25 May 2020

RE: Proposed redevelopment of Trinity Grammar School SSD-10371

Stage 3 (Continued)

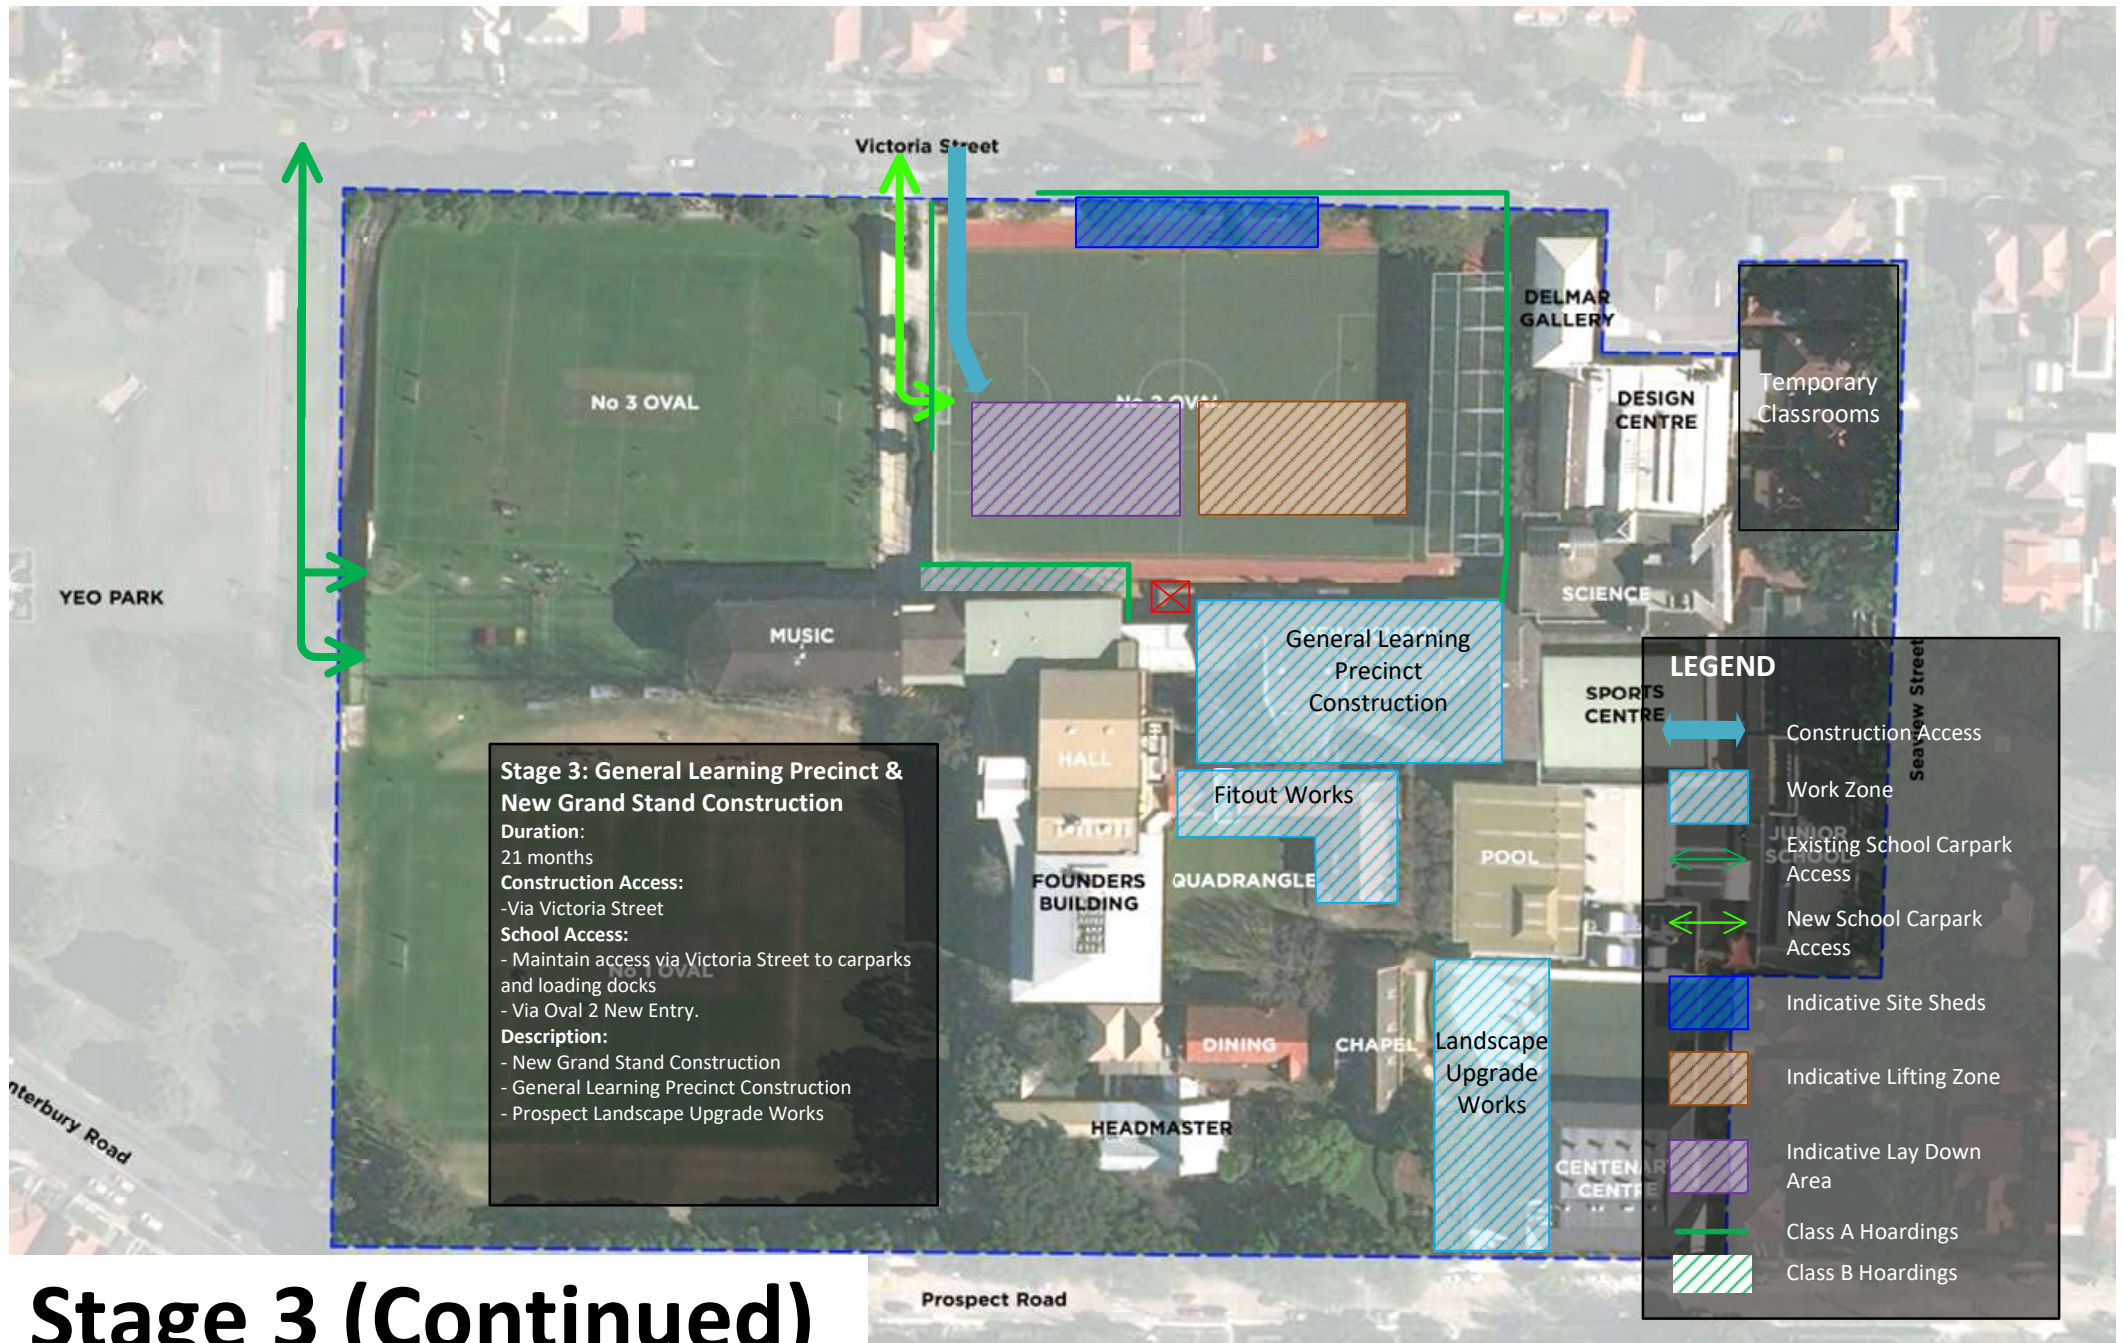
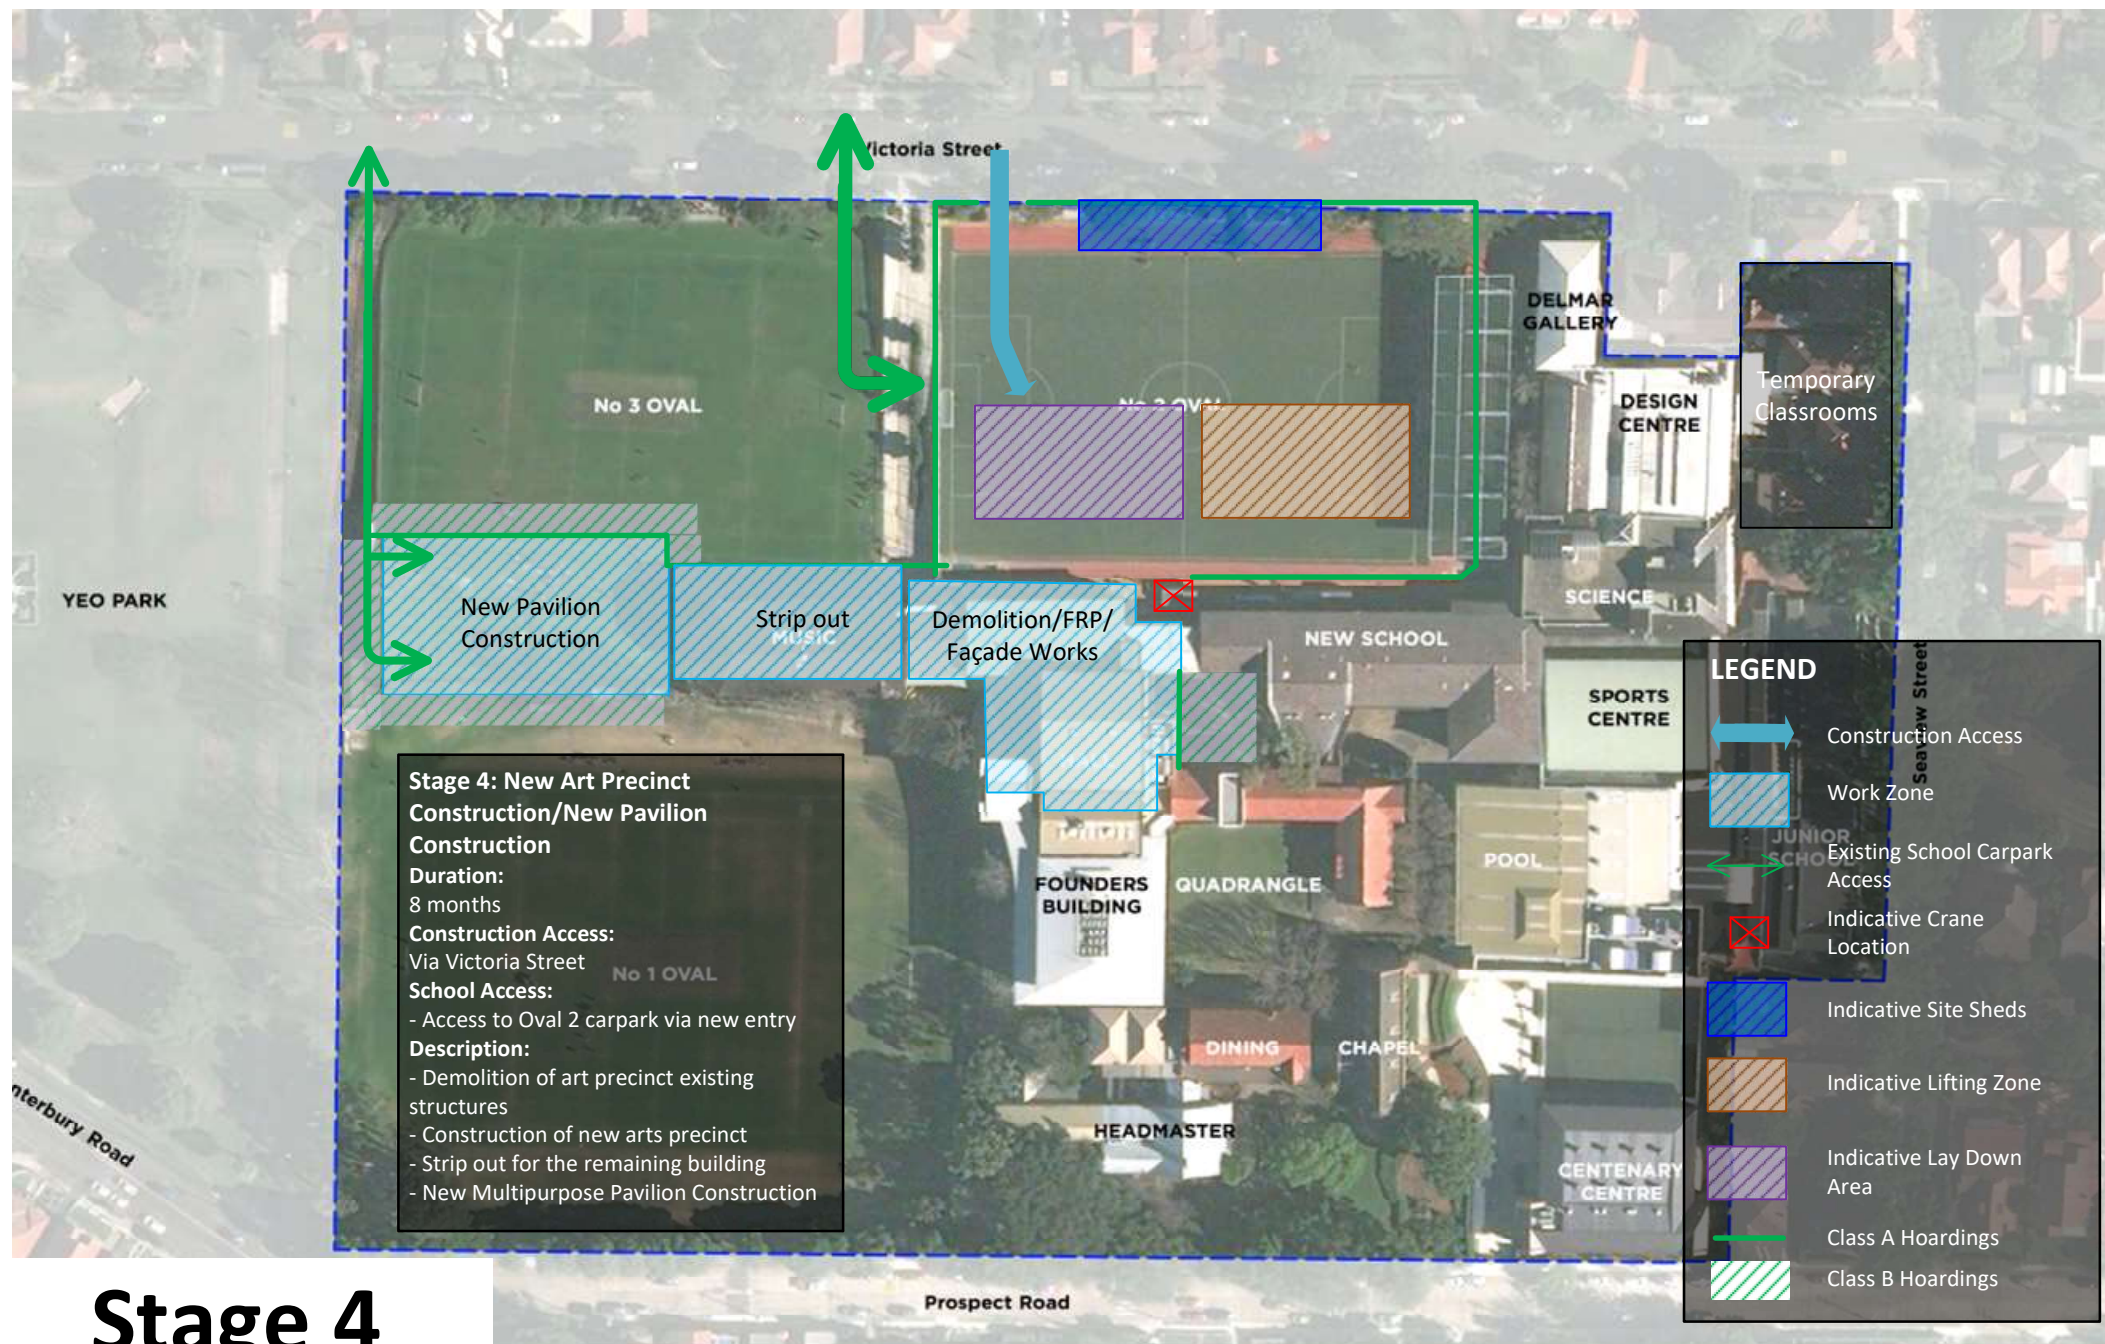
I am very concerned that it is proposed to establish a construction site access opposite my residence (corner of Holwood Avenue) for a minimum of four years (2021-2015). This is a very long duration where residents will be subject to the arrival/departure of articulated vehicles, heavy rigid vehicles, concrete trucks etc. This is not in keeping with a school that states it is "mindful of noise impacts to neighbours", most of whom are unable to screen themselves from the adverse amenity impacts the school generates due to conservation zone restrictions.

Stage 4 Appendix 18A Construction site access (red arrow): Nov 2023 to Jul 2025 (1.5 years, Appendix 18B)
